23 June 2015

The Director of Planning Services
Arun District Council
Maltravers Road
Littlehampton.

31 Sea Way Ref. No. M/56/15/HH

Proposed Floor Plans
- Ground Floor
- First Floor
- Roof Plan

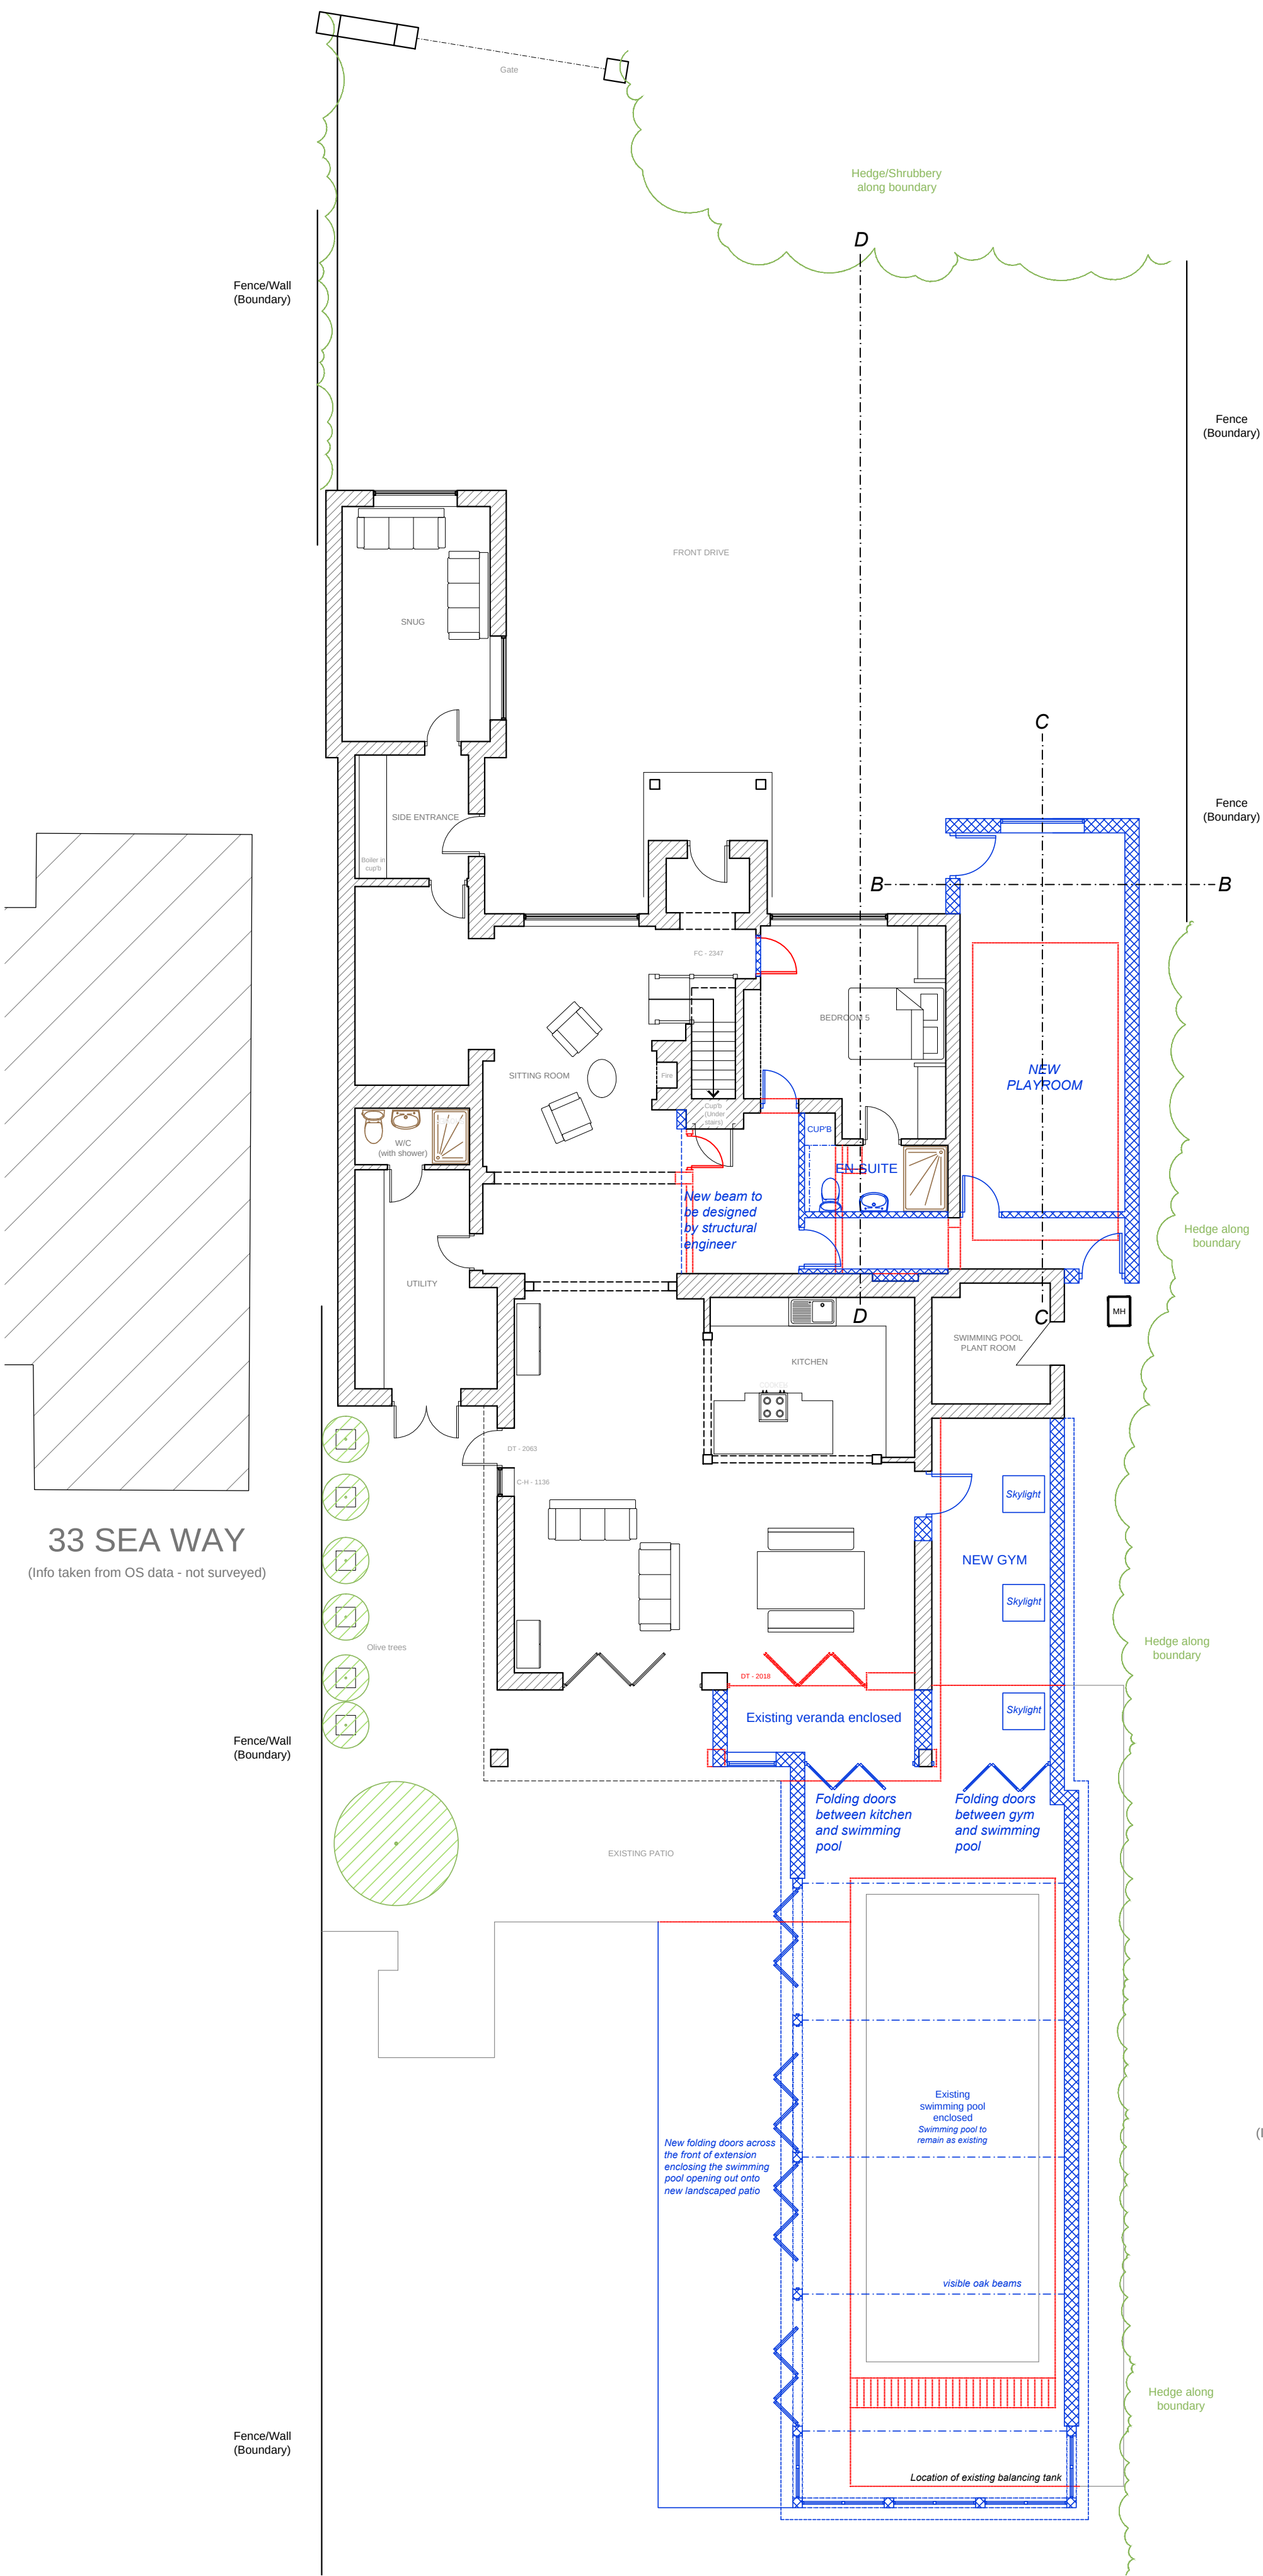
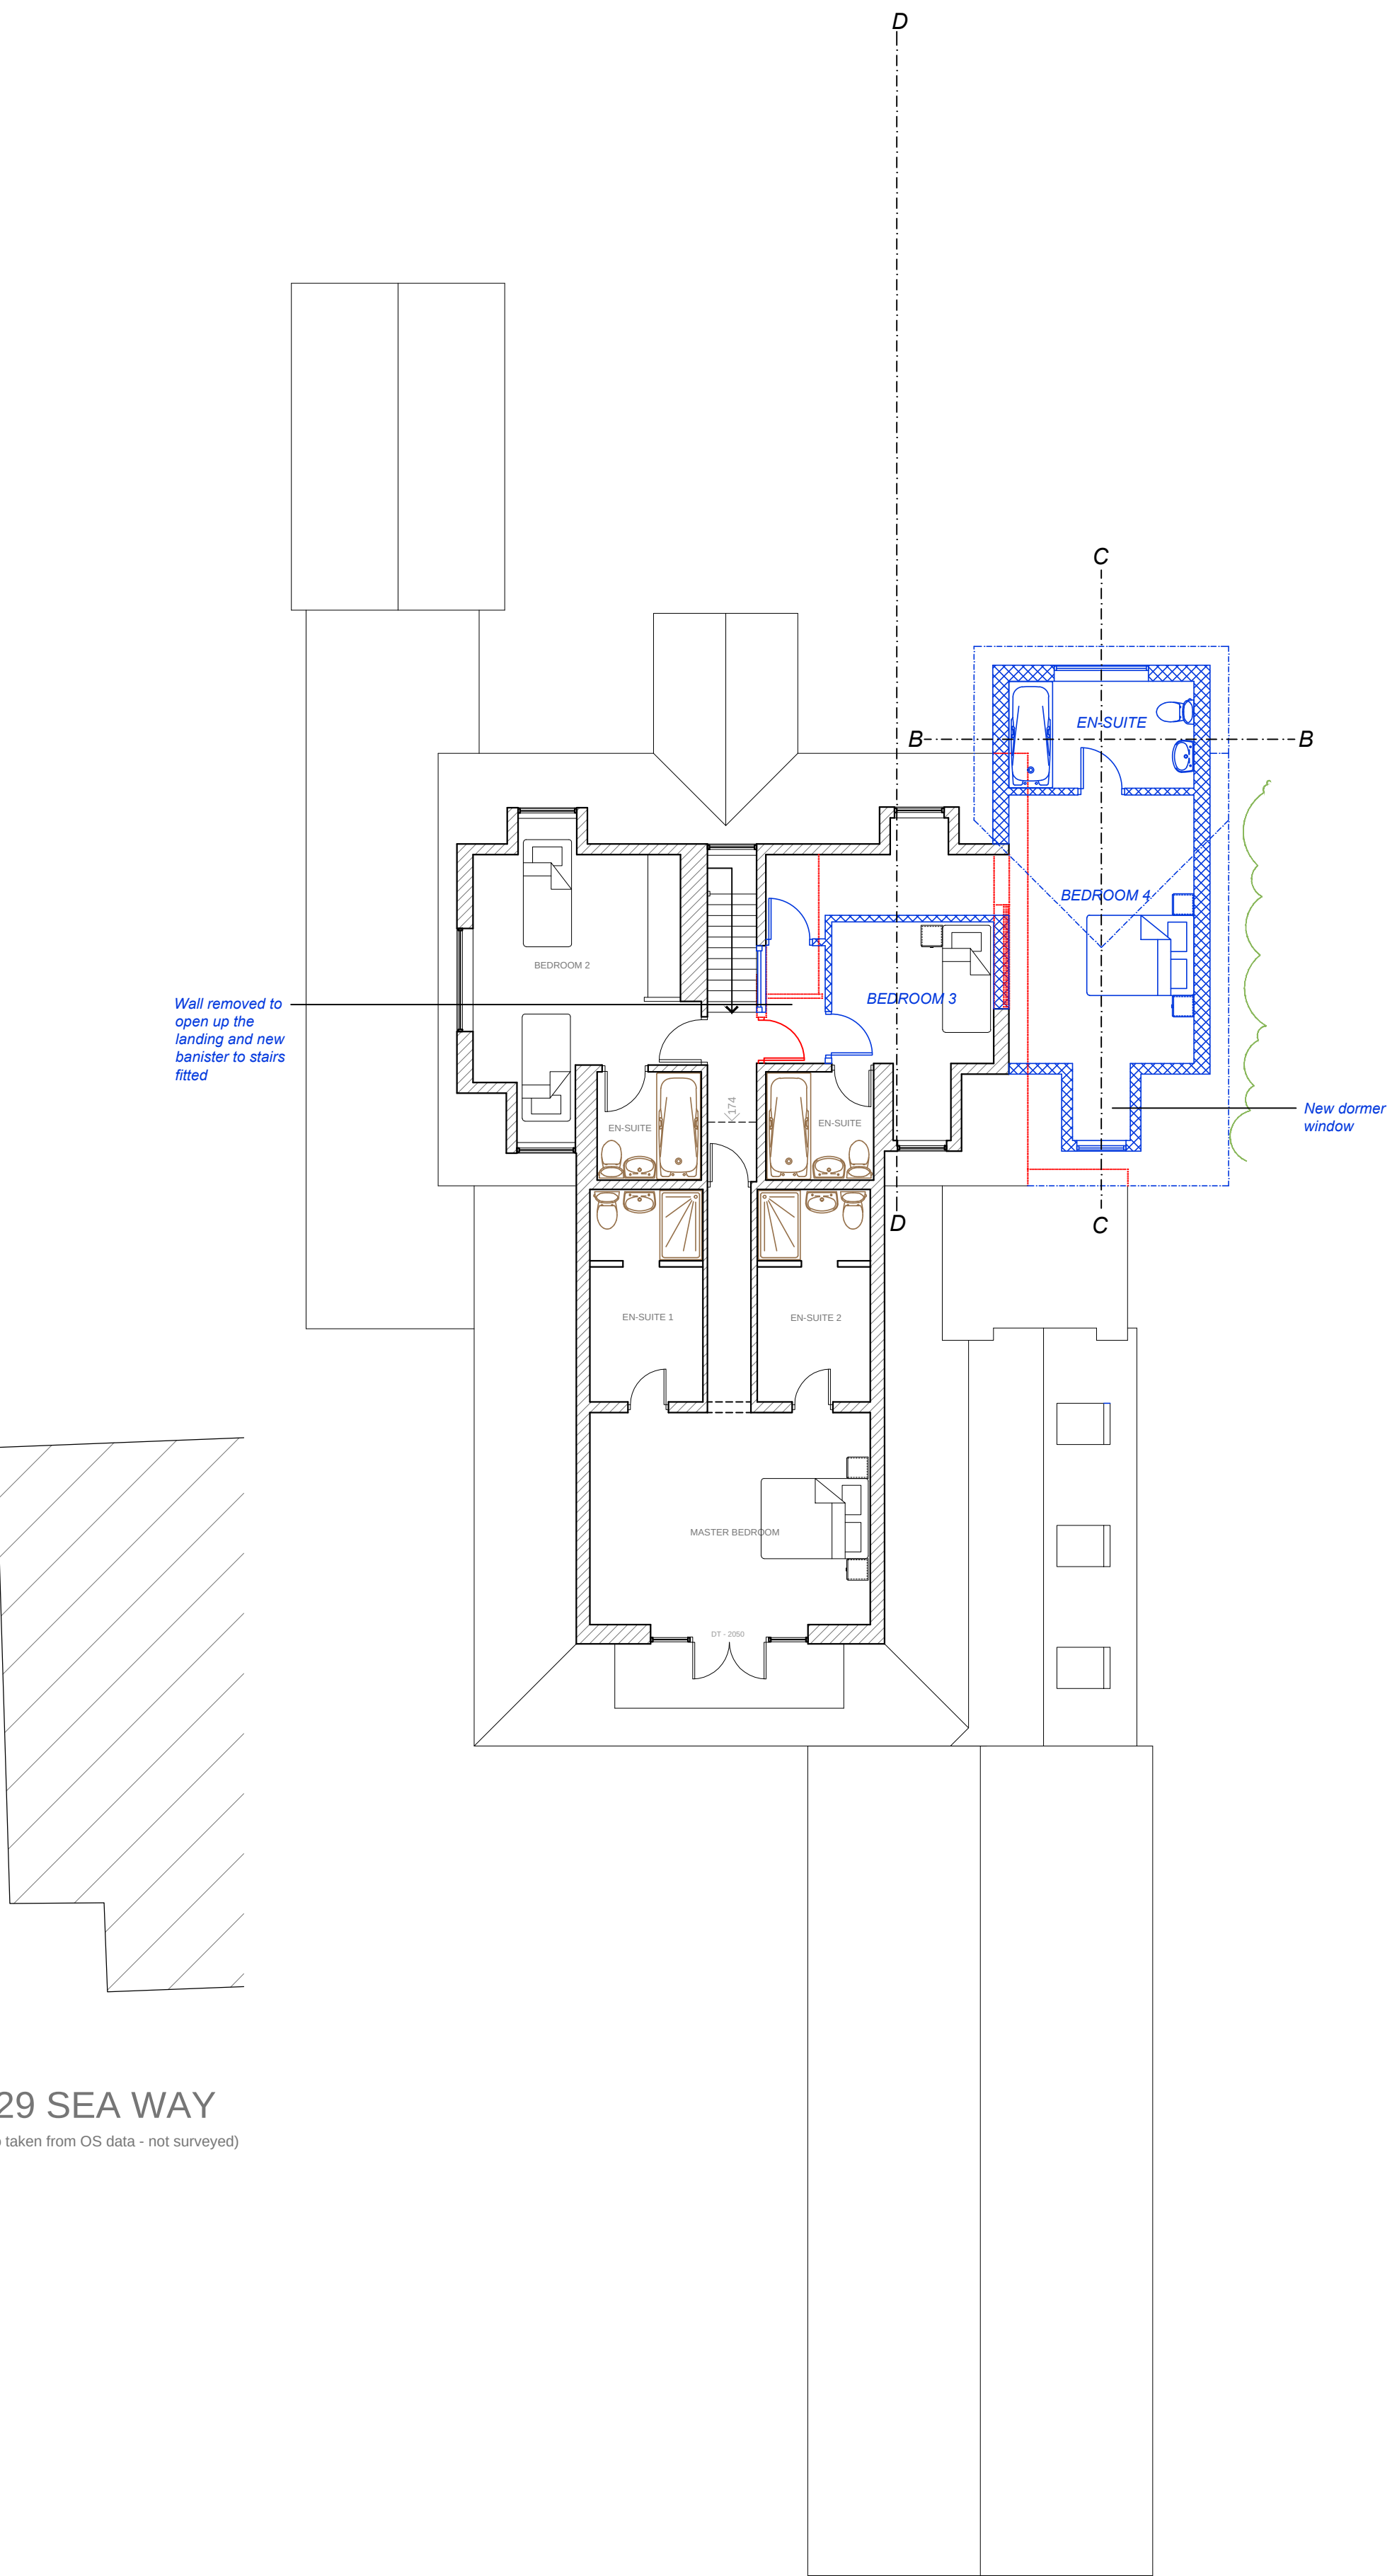
I am writing to urge you to reject this application on the grounds that the additional structures will create a gross over development of this small site, the overbearing nature of the buildings upon the adjoining property, No. 29, and, particularly, the proposed garage and store in the front forecourt.

I do not believe that any case can be made for any further building in the front forecourt. I am aware that there are garages in three of the adjoining houses but in all these cases the garages are in much larger sites well set back from the front verge and far smaller than the large structure proposed so close to both front and side boundaries. Any building in this position will stand out visually from the roadway and will be out of keeping with the adjoining properties.
